7 RAILWAY STREET, CHATSWOOD

ACCESS REVIEW

Morris-Goding Accessibility Consulting

21st July 2010

title: Levels 14 - 25 Floor Plans

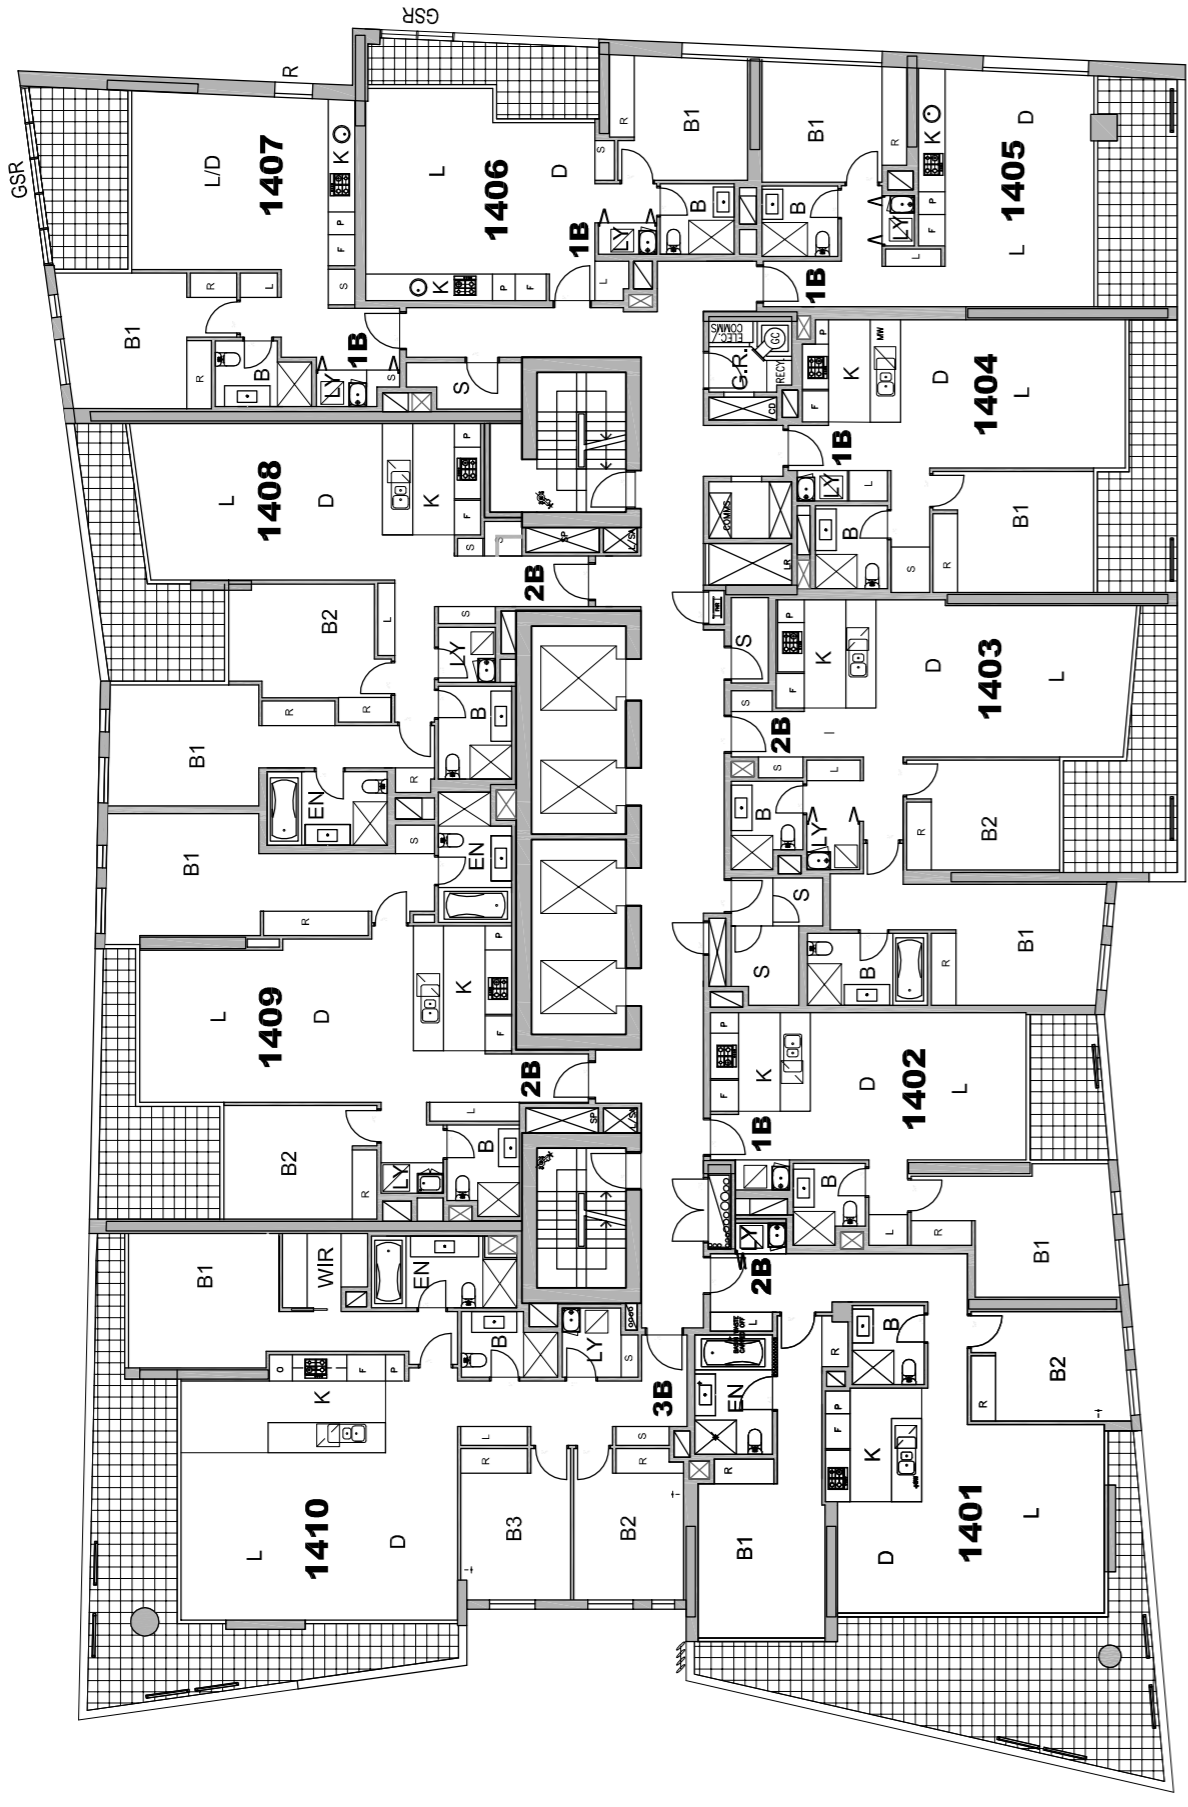
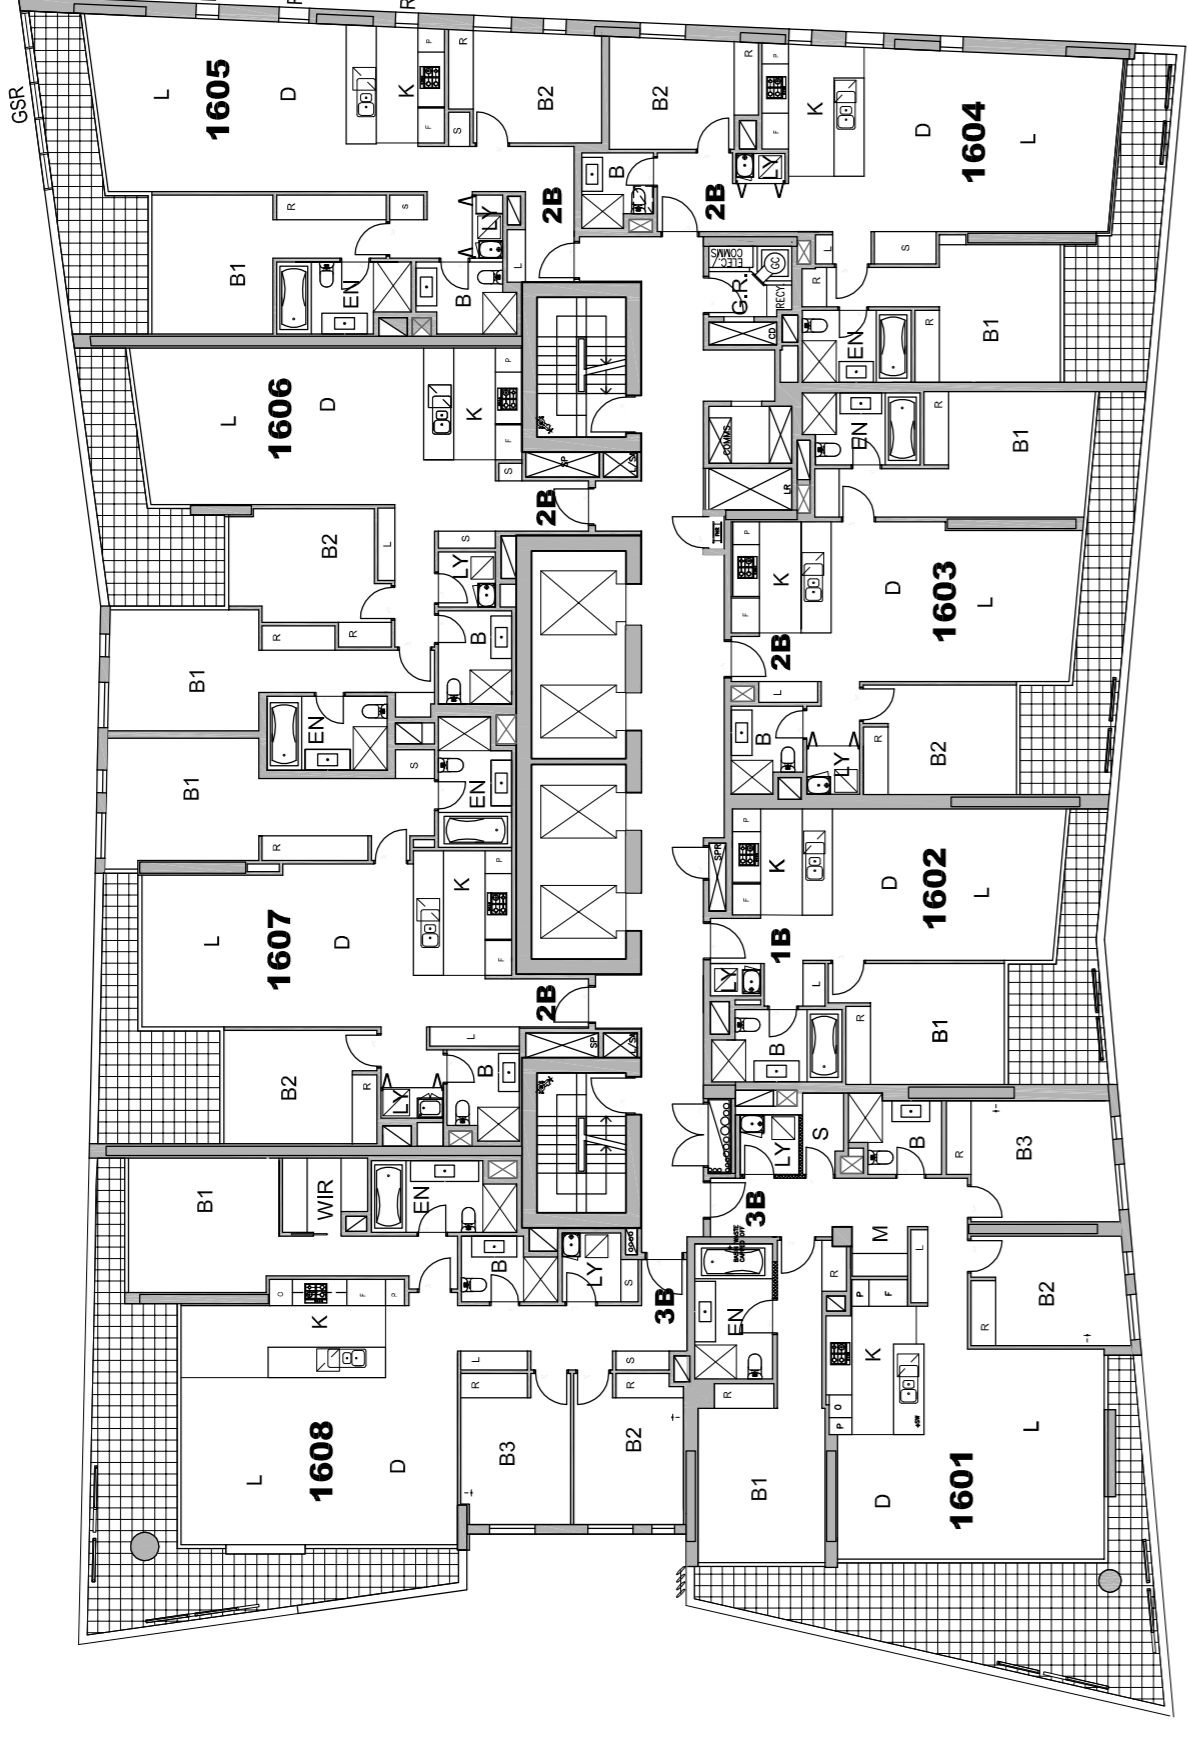
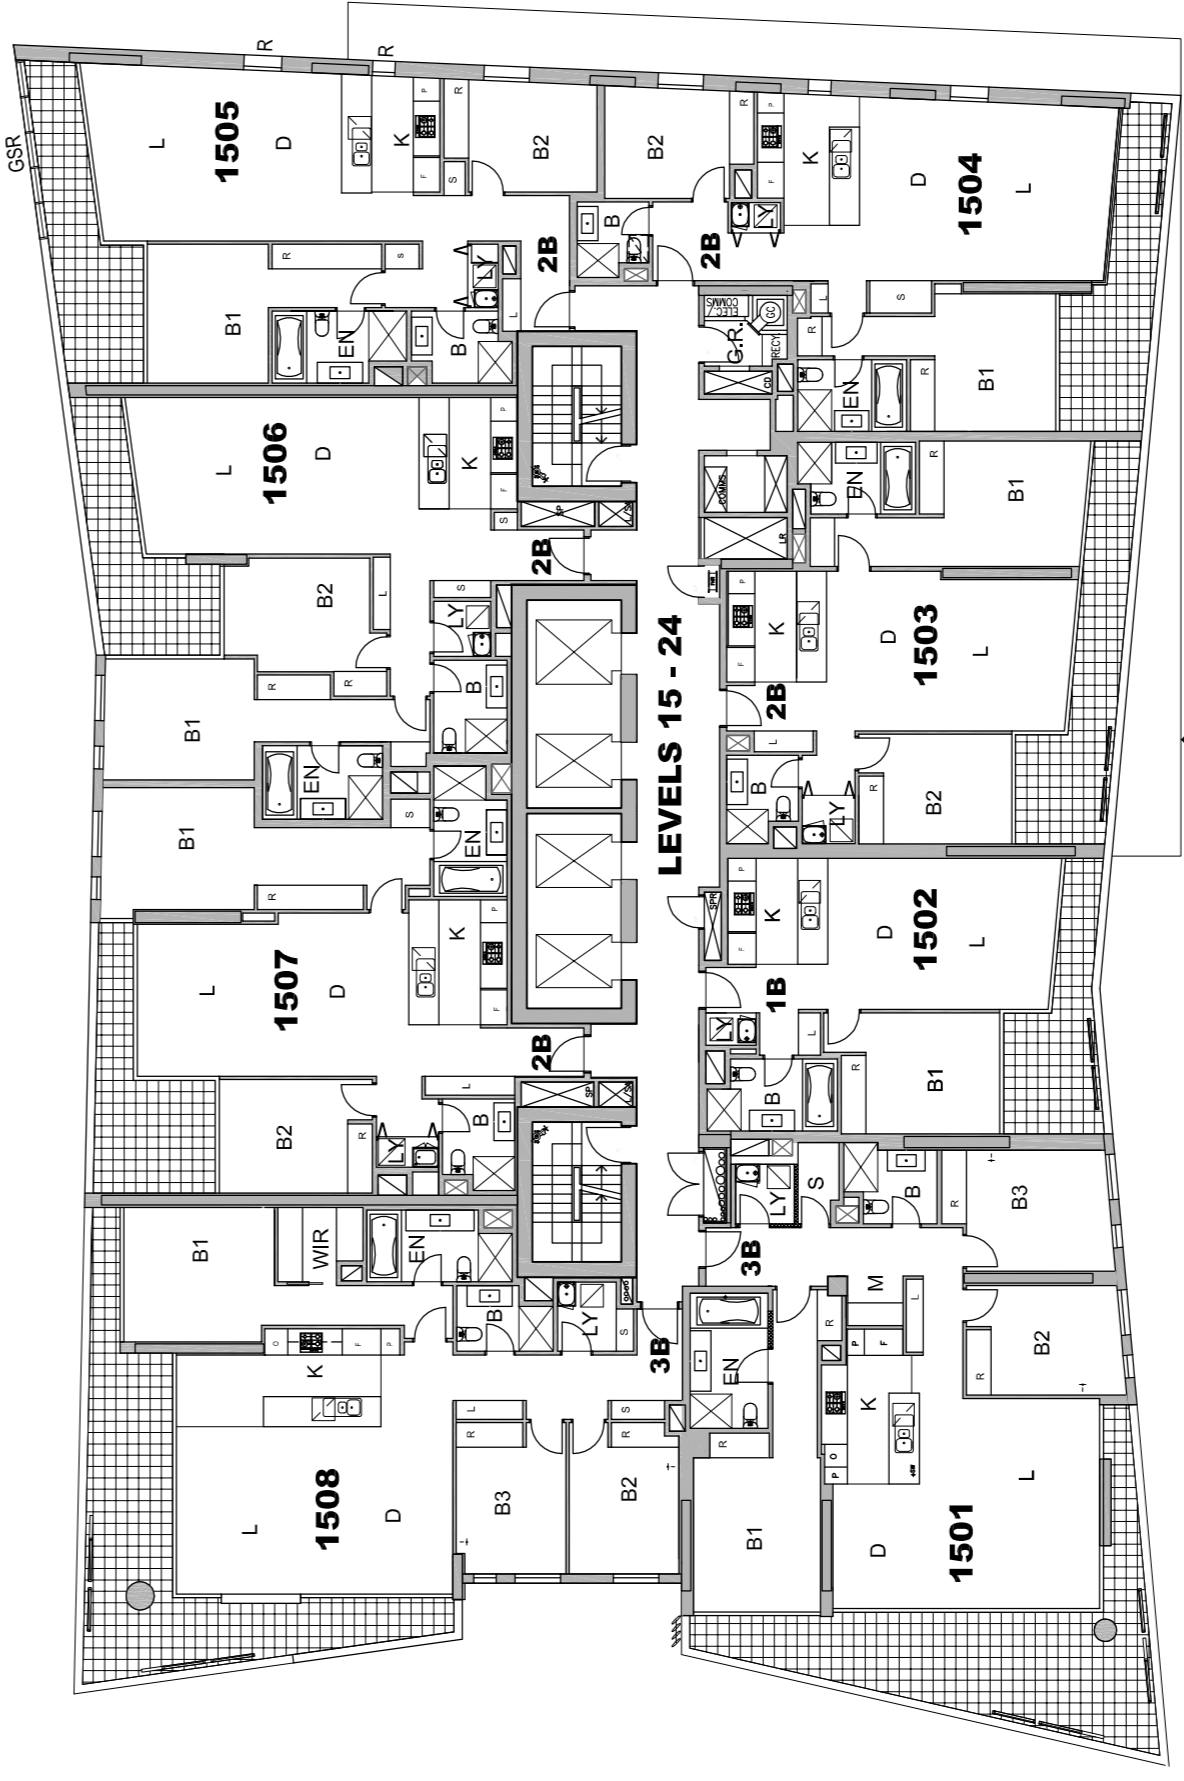
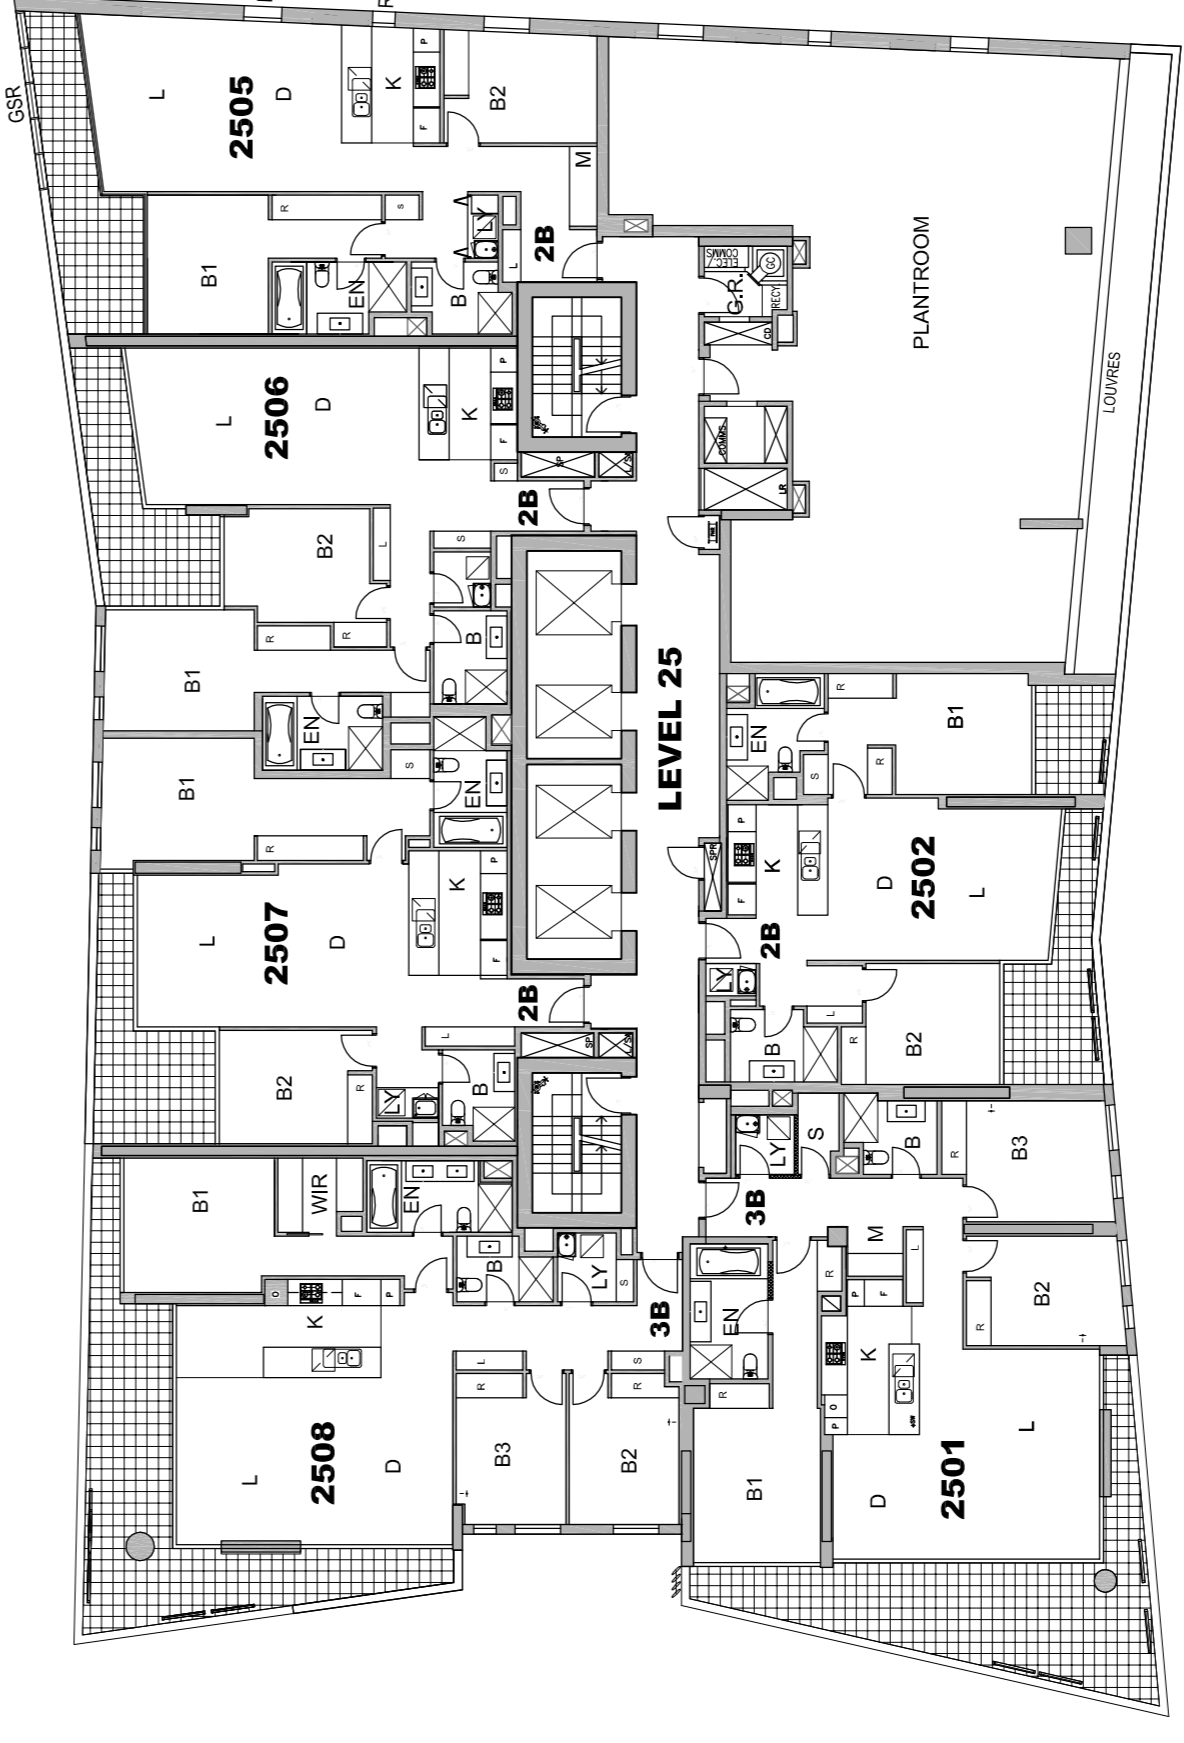
The three adaptable unit types are: unit 1201 and similar, unit 1501 and similar, and unit 2601 and similar. The following comments are applicable to all three unit designs.

There is a clear width of 850mm at the unit main entry doorway at pre-adaptation stage, and there is suitable internal and external latch-side clearance at the unit main entry doorway at pre-adaptation stage, which is compliant with AS 4299.

There is a suitable clear width of 820mm at entry doorway to the main bedroom and to the main bathroom. The provision of a clear width of 820mm at the remaining internal doorways for compliance with AS 4299 clauses 4.3.3 and 1.4.3 is achievable during design development.

There are corridor clear widths compliant with AS 4299 throughout the units at both pre- and post-adaptation stages.

The provision of an unobstructed circulation area with a minimum diameter of 2250mm is achievable within the living room after the placement of furniture at post-adaptation stage, which is compliant with AS 4299.

The provision of a clearance of 1550mm between kitchen benches at post-adaptation stage within each of the unit designs is achievable, compliant with AS 4299. The cooktop is separate from the wall-mounted oven at post-adaptation stage, compliant with AS 4299. There is an 800mm-long bench adjacent to the cooktop and the wall-mounted oven in the kitchen at post-adaptation stage, compliant with AS 4299.

The provision of a clearance of 1550mm in front of laundry appliances at post-adaptation stage is achievable, compliant with AS 4299.

There is one bedroom which has internal dimensions at pre-adaptation stage which will accommodate the provision of all of the following at post-adaptation stage: a queen-size bed, a clearance of 1000mm on either side of the bed, a clearance of 1200mm at the foot of the bed, and a circulation area a minimum of 1550mm in diameter. This is compliant with AS 4299.

There is one bathroom which has internal dimensions at pre-adaptation stage which will accommodate the minimum combined pan, washbasin and shower circulation requirements under AS 1428.1. This is compliant with AS 4299.

The provision of a suitable continuous accessible path of travel to the unit balconies at post-adaptation stage is achievable.
